26 February, 2013

The Director General
Department of Planning
23-33 Bridge Street
Sydney, 2000

Southlands Remediation and Development Project – Modification under S.75W of Project Approval - 06_0191 – Reconfiguration of Compensatory Flood Storage Basin, Reconfiguration of Lots 7, 8 and 9, Reconfiguration of Lots 3-6 Boundary, Addition of wording requested by OEH Accredited Site Auditor

Lot Area Schedule	
	Approx Area
Lot 1	2.80 ha
Lot 2	2.43 ha
Lot 3	1.05 ha
Lot 4	0.91 ha
Lot 5	0.99 ha
Lot 6	1.21 ha
Lot 7	1.44 ha
Lot 8	1.16 ha
Lot 9	5.44 ha
Lot 10	Orica pipeline Lot
Lot 11	Orica pipeline Lot

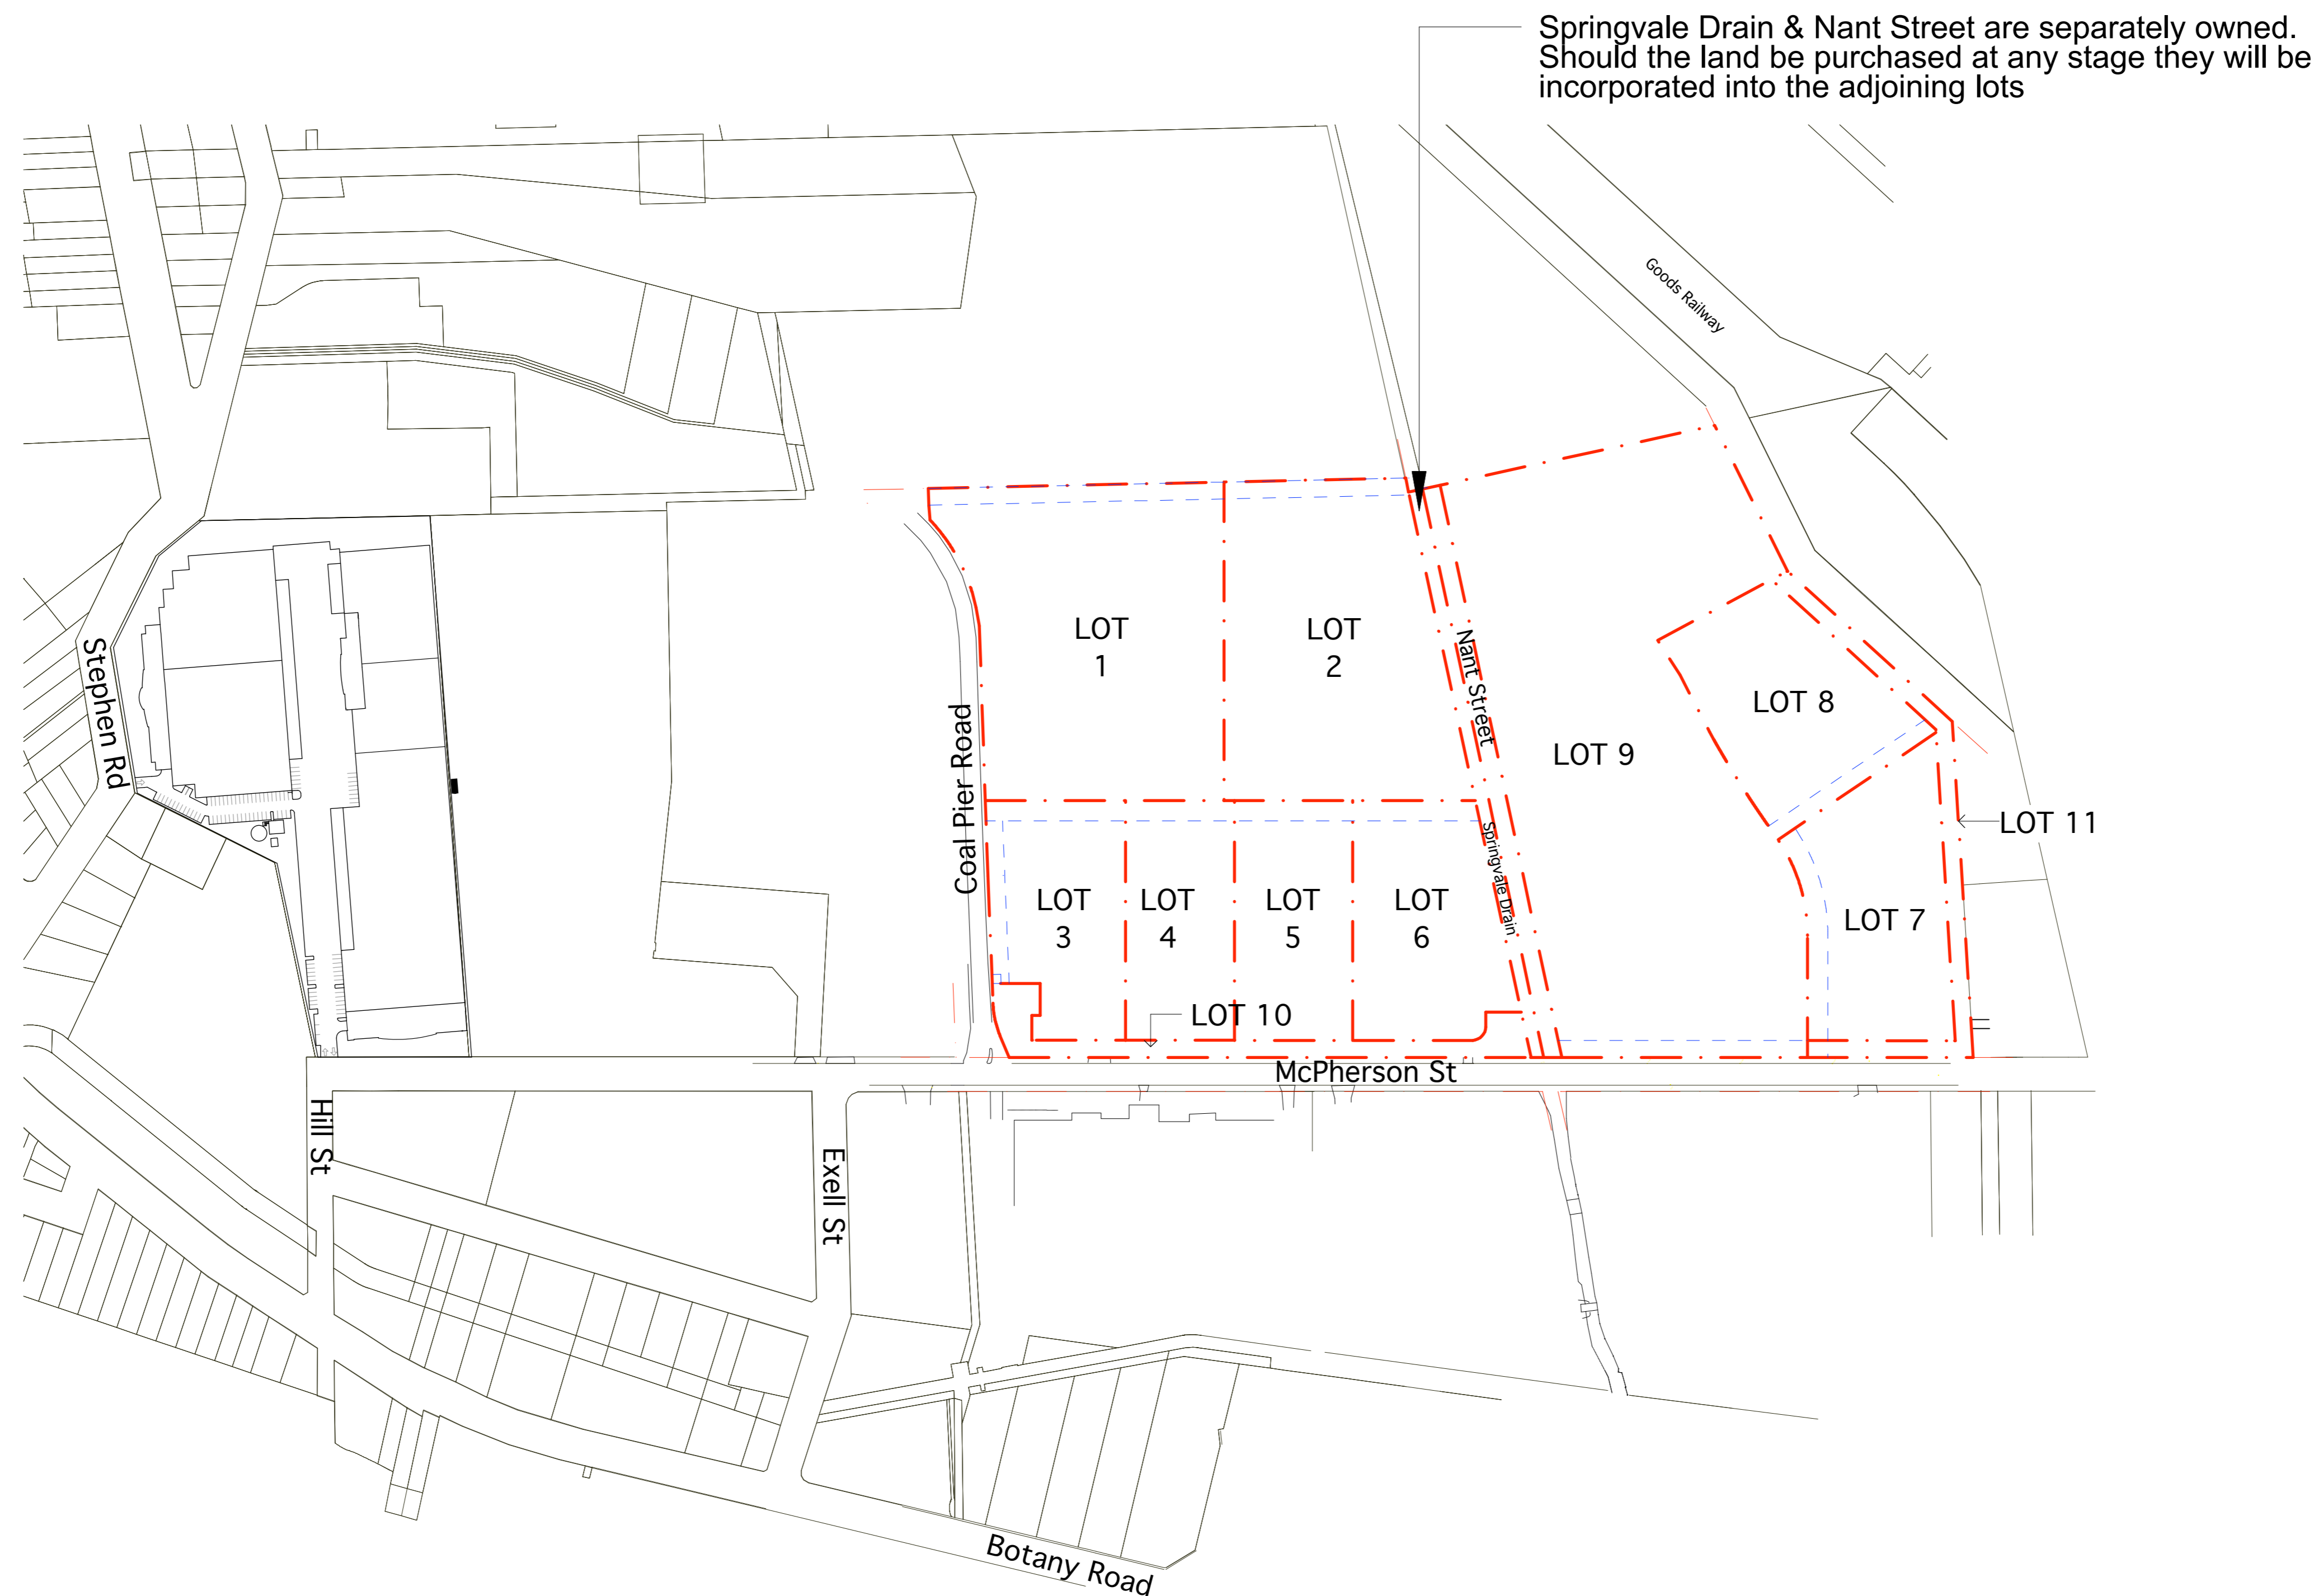
This modification comes about due to a desire to provide a better, wider lot frontage for Lot 3 (allowing for the retention of key Orica infrastructure at the corner of Coal Pier Road and McPherson Street). As a consequence Lots 3 – 6 have been marginally shuffled along McPherson Street, varying their frontages and overall lot sizing.

In addition the internal driveway that previously served Lots 1 and 2 only, is now proposed to form part of Lots 3 – 6, allowing all lots to have access to this driveway. This provides for an improved access and circulation system allowing trucks to move through the sites in a one way direction, minimising conflicts with cars on Lots 3 – 6. The driveway is shown as part of Lots 3 – 6 with reciprocal ROW's ensuring maintenance of the driveway by landowners in favour of all other users.

The new modified lot layout is therefore shown on modified plan SRD DA016 (G), which shows the modified lot areas.

Date	Datum	Scale	Size
JAN'13	AHD	1:1000	A1
Drawing Number: 210094-DA-001			Revision B

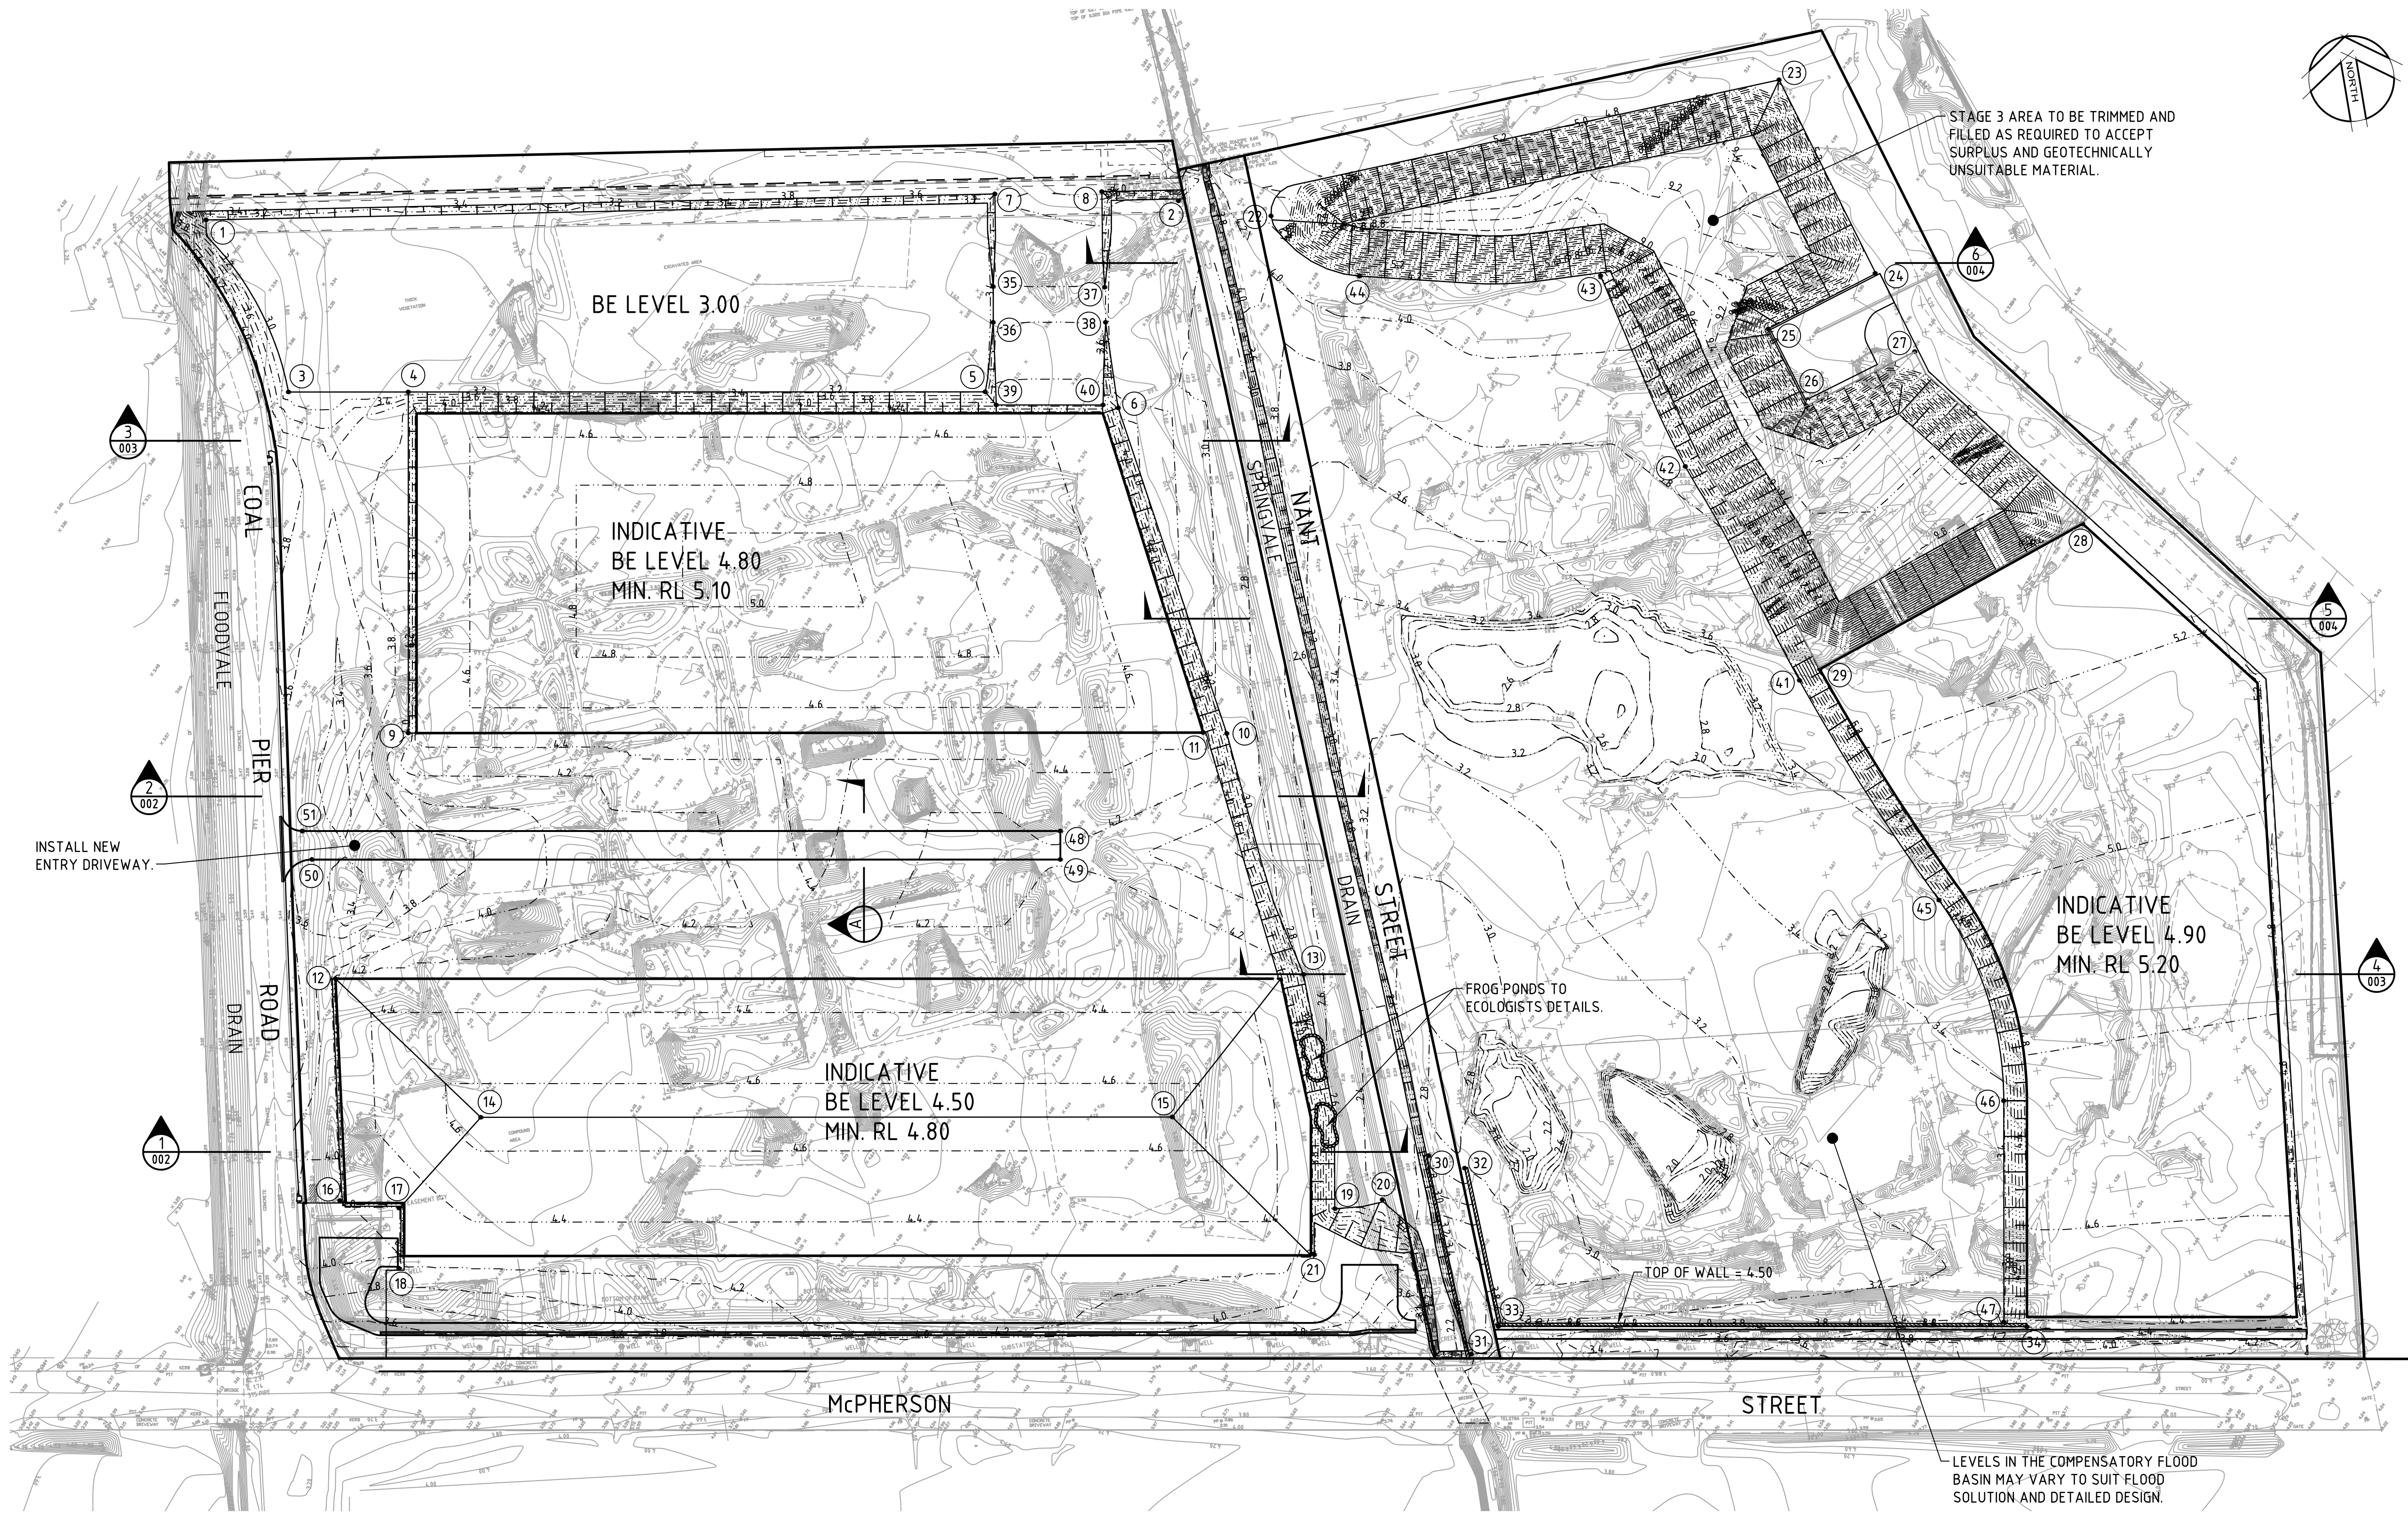
In accordance with the revised compensatory flood basin updated bulk earthworks drawings defining the extent of earthworks across the site to deliver the updated basin and flood free areas are therefore attached. These drawings are proposed to replace the previous Aurecon Civil Drawings C010 and C020. (see summary of modified drawings table.

C010	Bulk Earthworks Plan – Stage 1	Yes	Modified to show amended basin plan and flood free areas Replaced with new Cardno Plan 210094-DA-001 (Rev. B)
C020	Bulk Earthworks Cross Sections – Stage 1	Yes	Modified to show amended basin plan and flood free areas and revised pad levels. Replaced with new Cardno Plan 210094-DA-002 - 004 (Rev. B)
